From: system@acelo.com on behalf of Mathew Rawson <mathew.rawson@penrith.city>
Sent: Tuesday, 3 May 2016 9:16 AM
To: Matthew Rosel
Subject: Submission Details for company Penrith City Council (org_comments)

Exhibition of Modification Request for PacLib Printing Warehouse and Distribution Facility, Erskine Park - MP 08_0016 Mod 3
Lot 2 DP 1203886, Lenore Drive, Erskine Park

Drawing title:
LOT 2 SITE PLAN

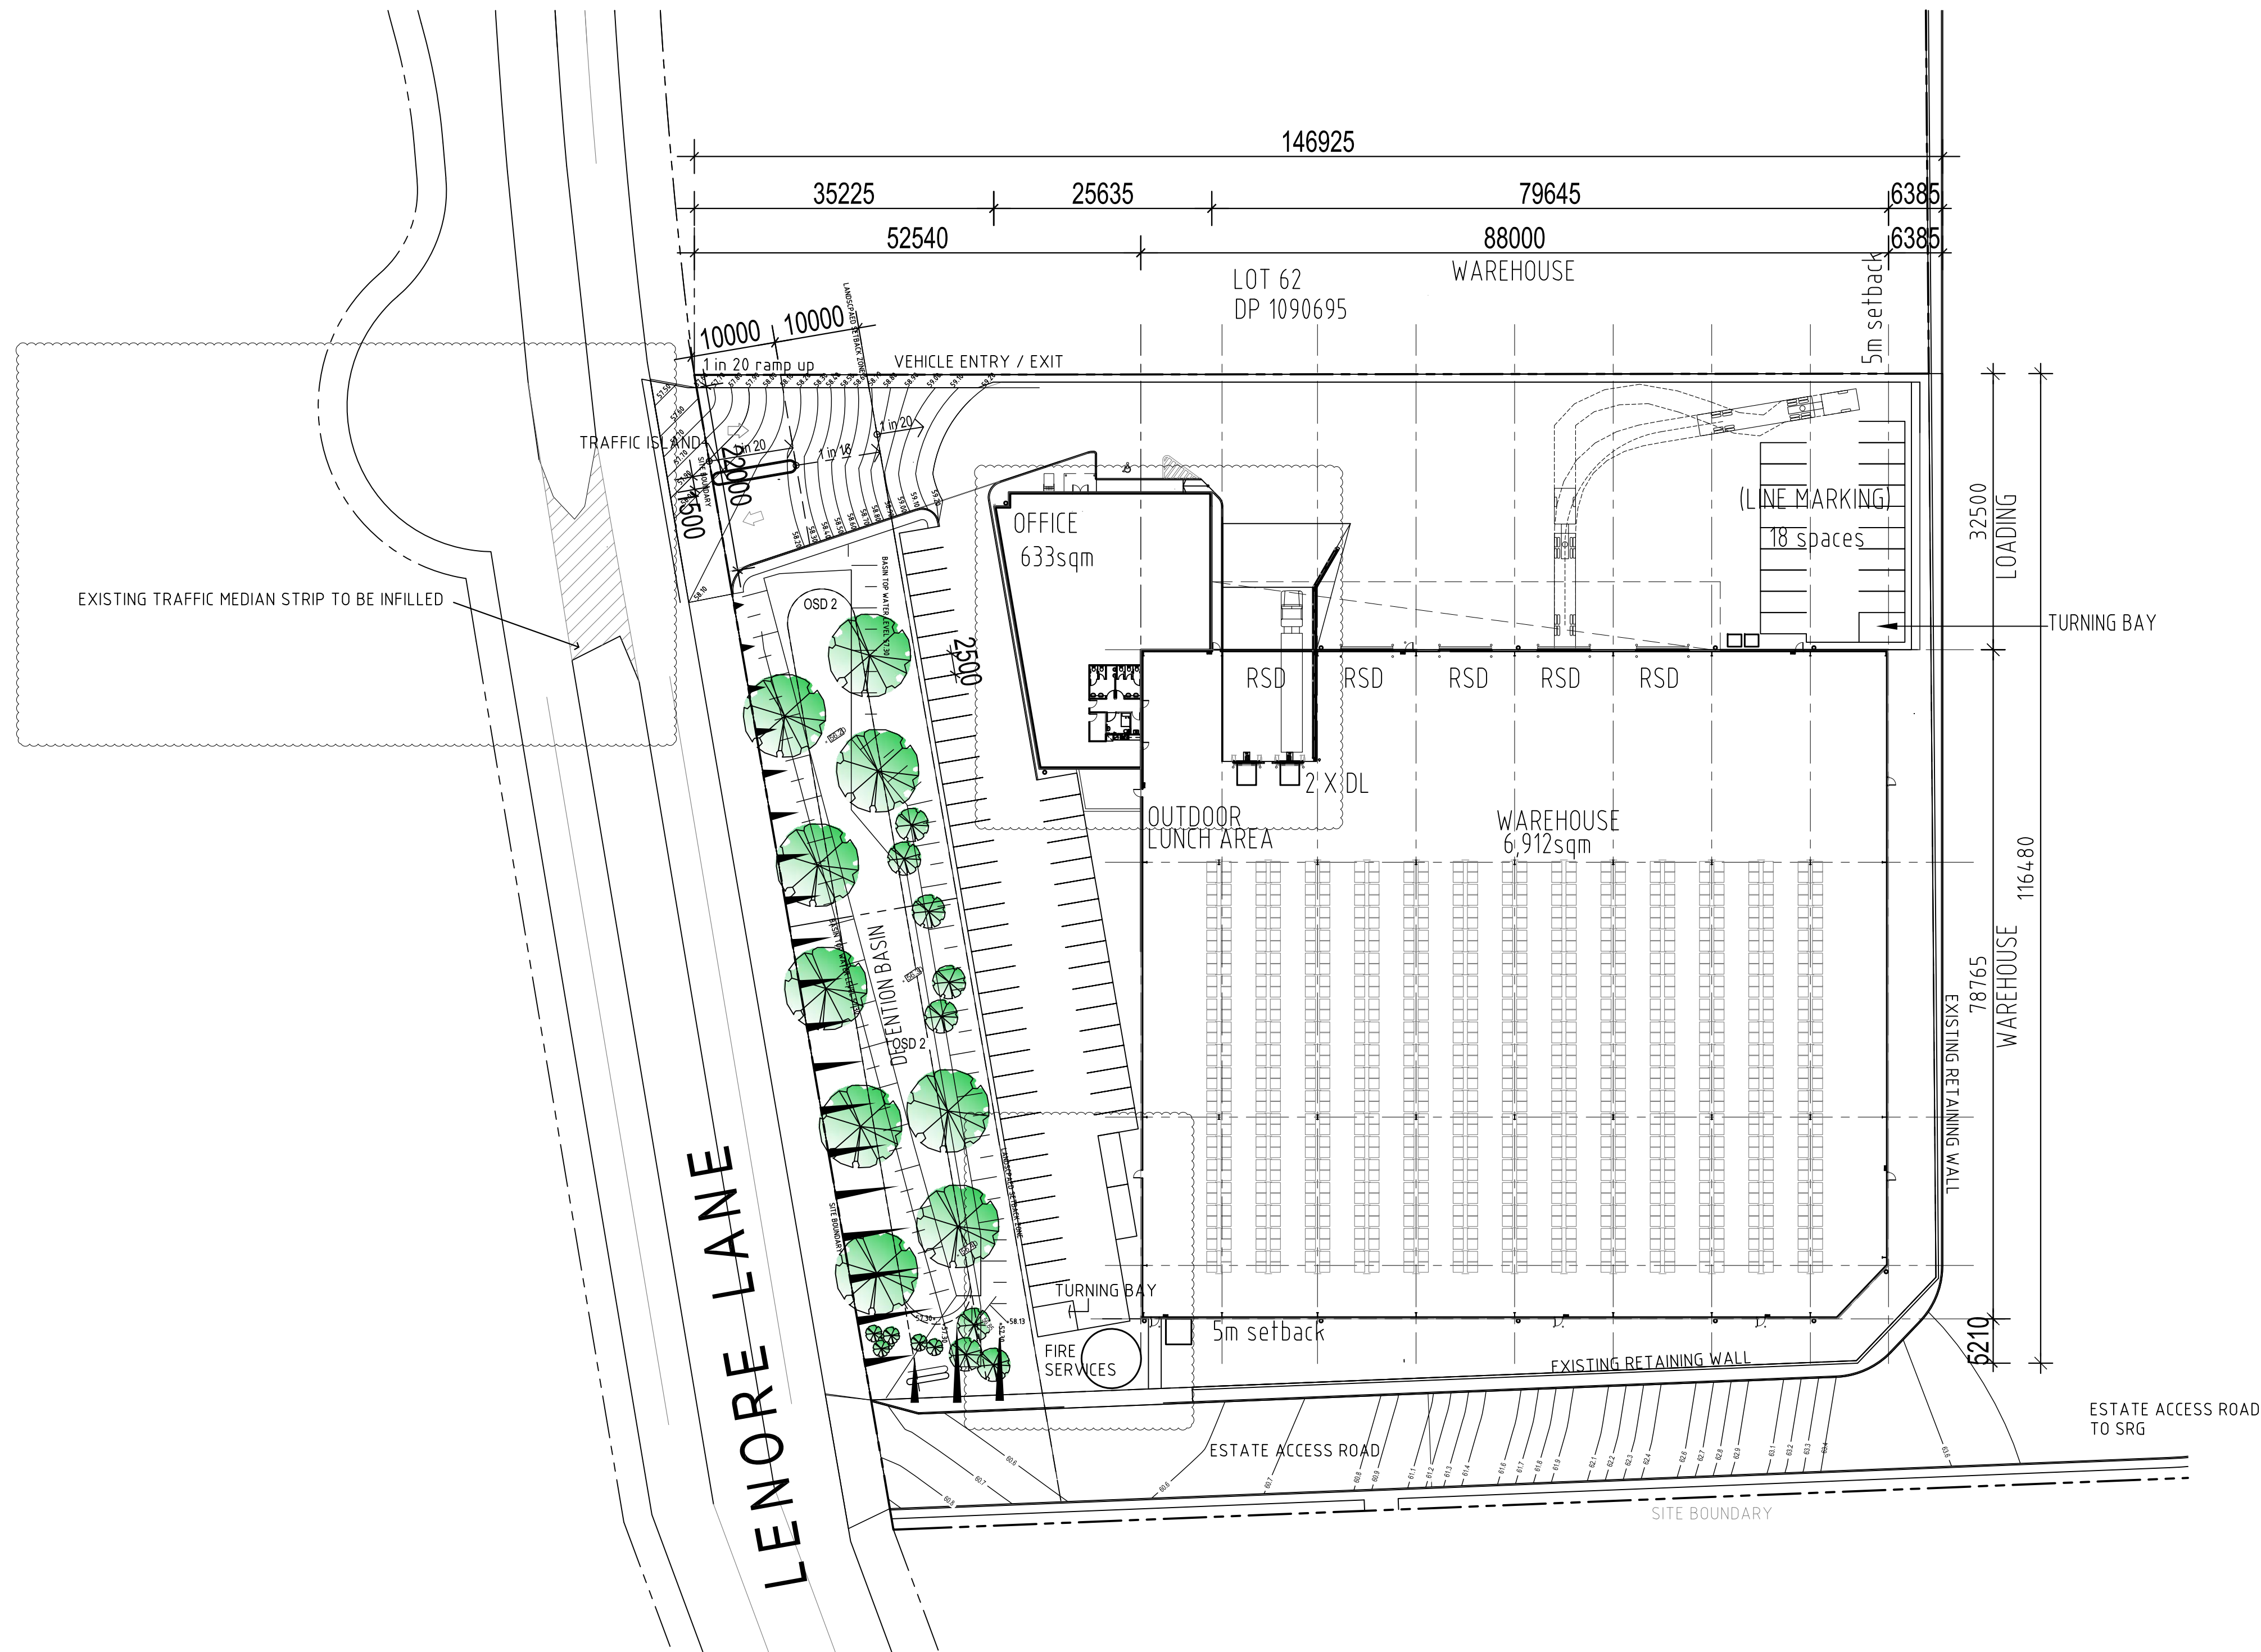
- o The modification will increase the visual prominence of the servicing requirements for the buildings such as the sprinkler tank. These aspects of the development should not be located within the front setback or be visible from public places. These requirements should be integrated with the building and landscaping design.

- o All front fencing shall be located behind the landscape setback and not along the front boundary, be a maximum height of 2.1m and of an 'open' nature. Such fencing should be black powder coat steel palisade fencing similar to that existing through the estate.

Drawing title:
BUILDING ELEVATIONS

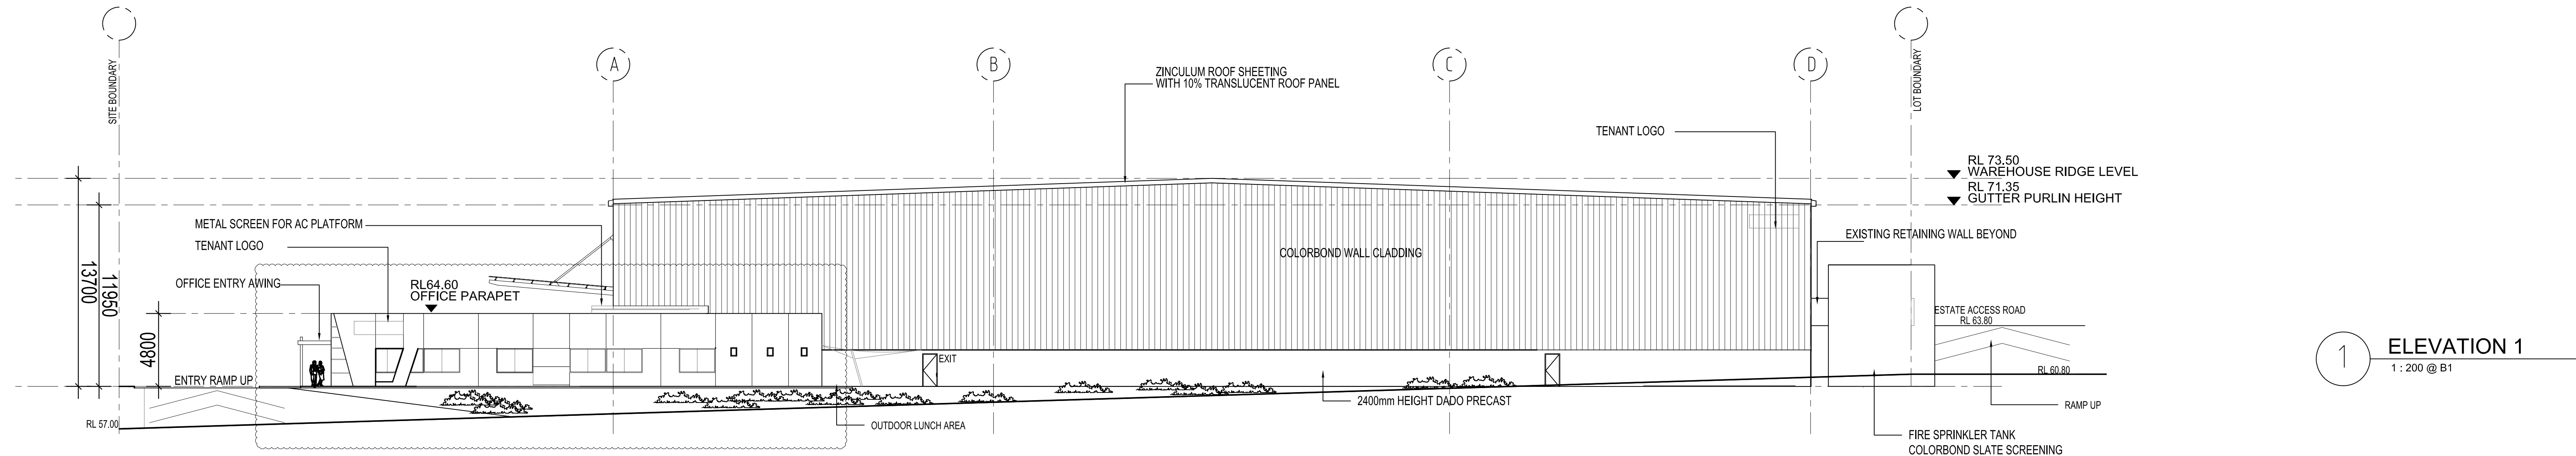
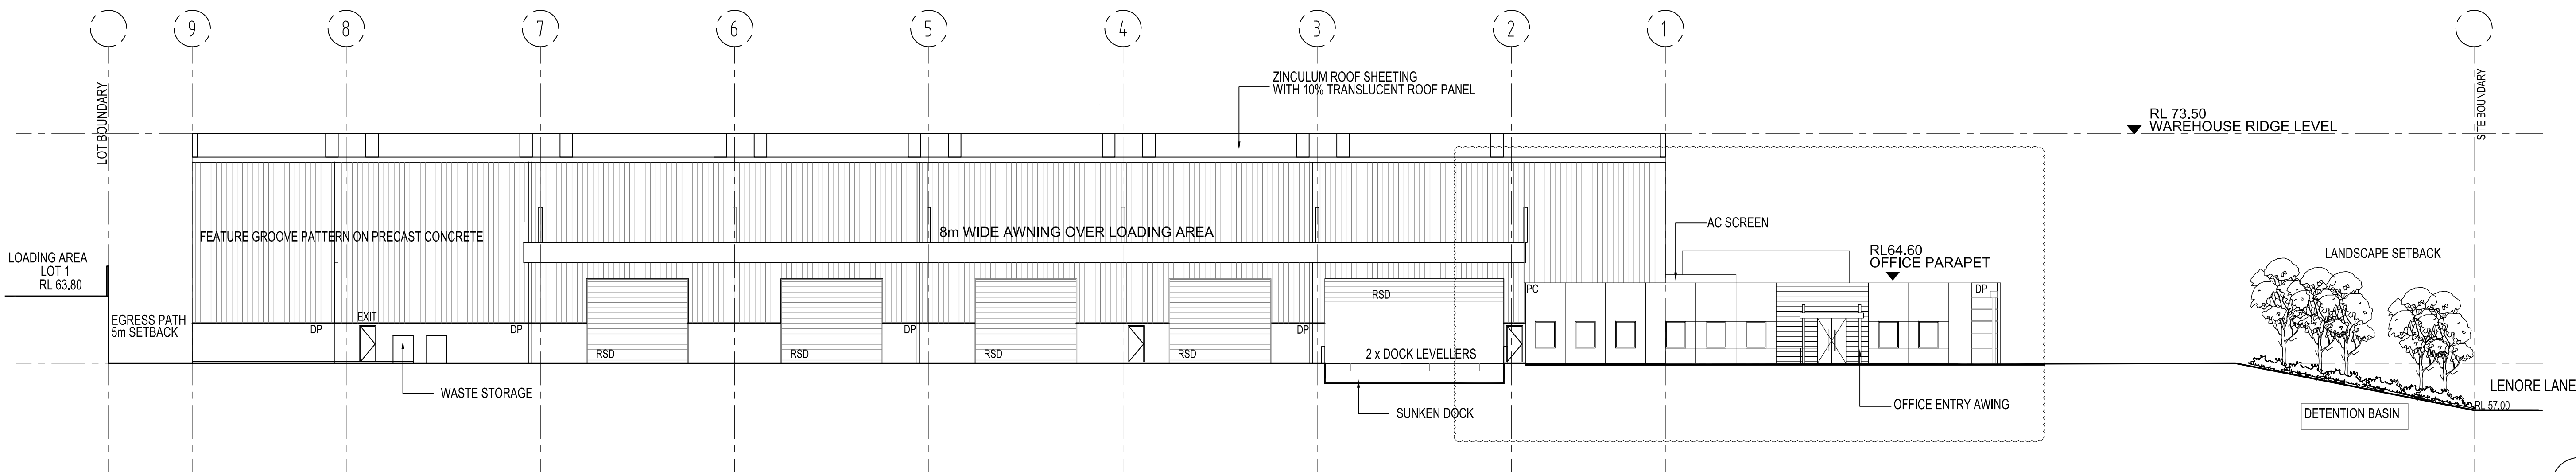
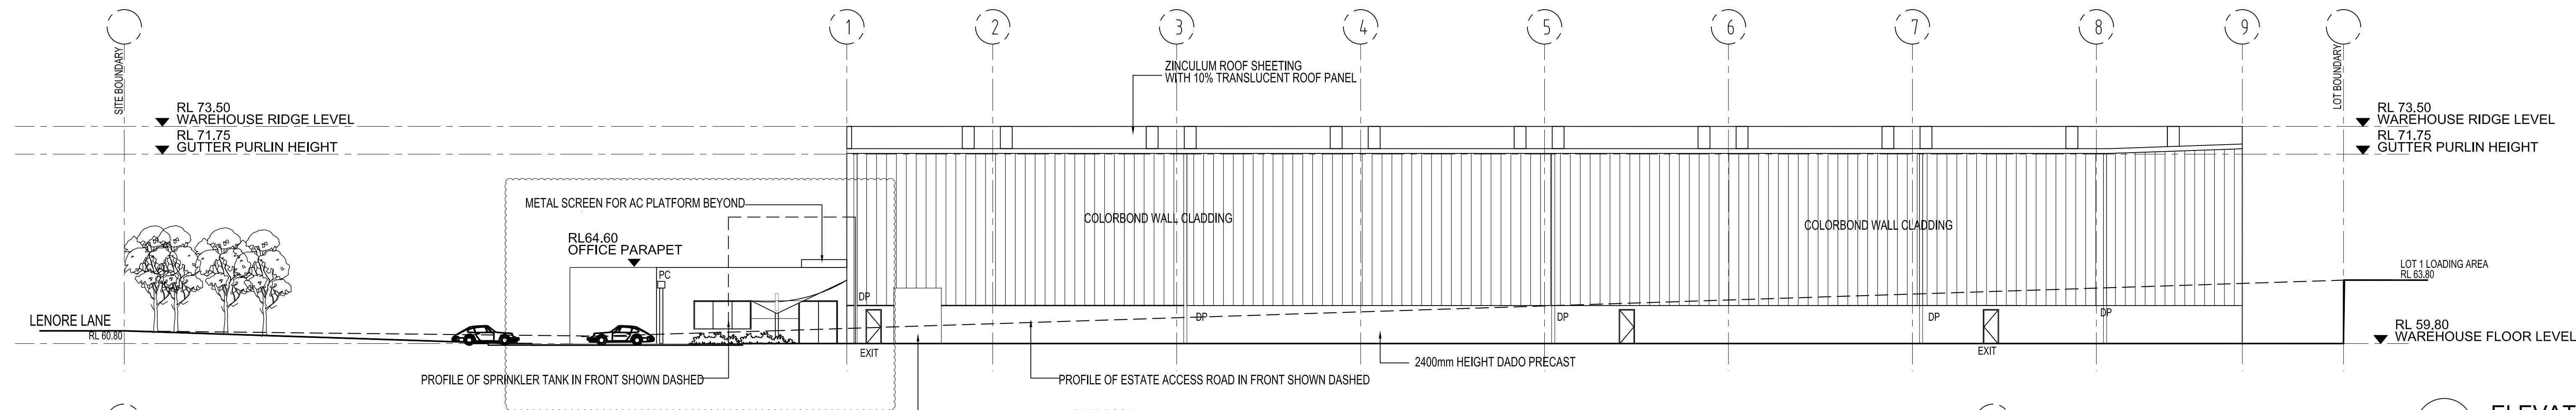
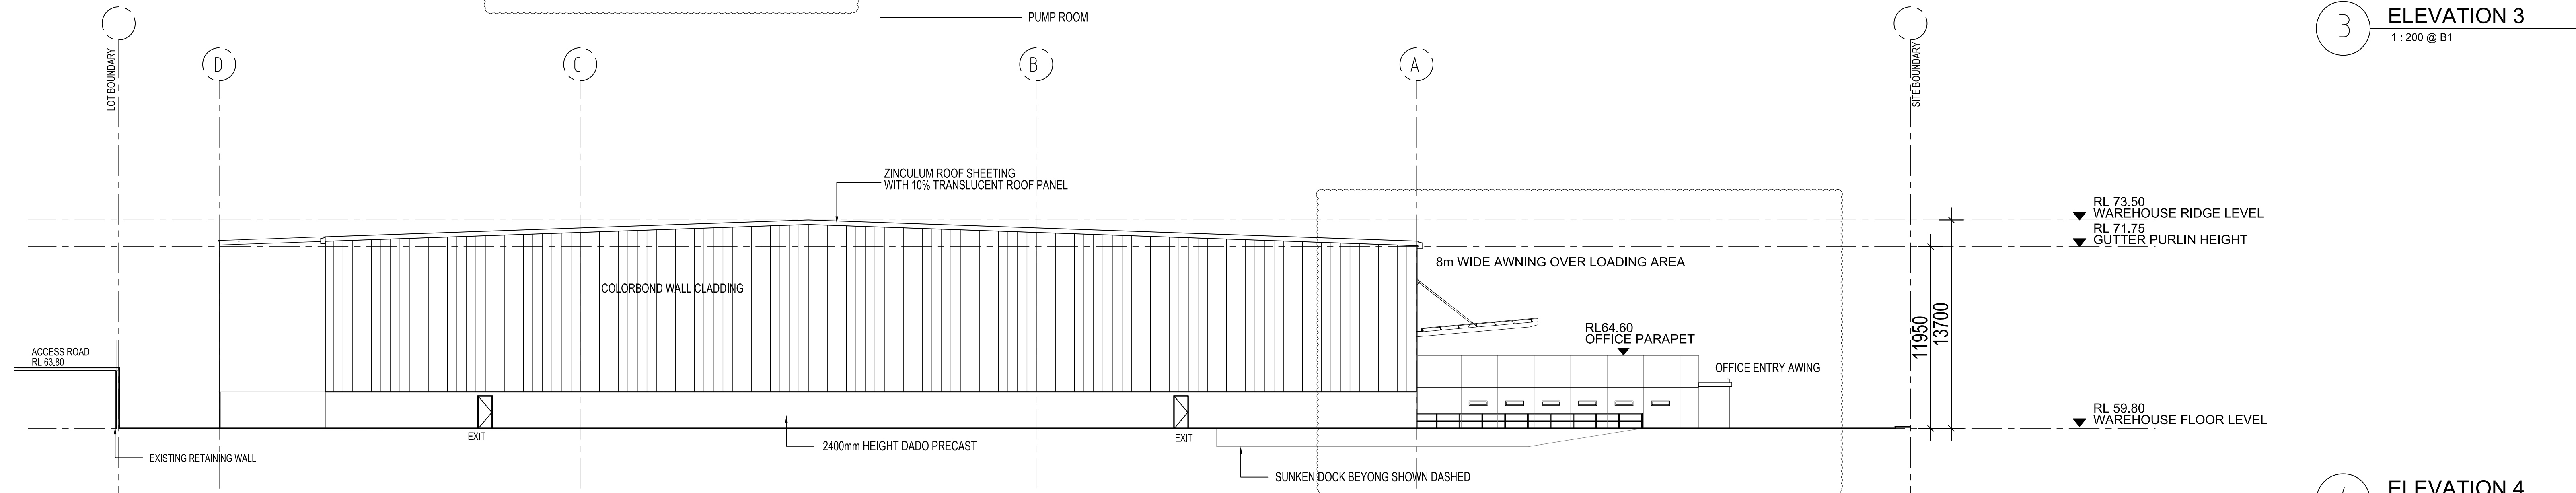
- o Large expanses of wall (eastern end of the southern elevation) are still proposed at the street frontage which should be broken up with by the use of additional architectural treatments, building articulation, fenestration and a variety of external finishes in terms of both colour and type of material used.

- o The proposed modifications reduce the prominence of the office component of the building. The presentation of the office building component was considered to be a key aspect of the development. The revised proposal is considered to be of significantly less architectural merit and its design does little to minimise perceived scale and mass. Although the development is located within an industrial estate the architectural design is important to prevent monotonous building forms resulting from poor design of walls or rooflines.
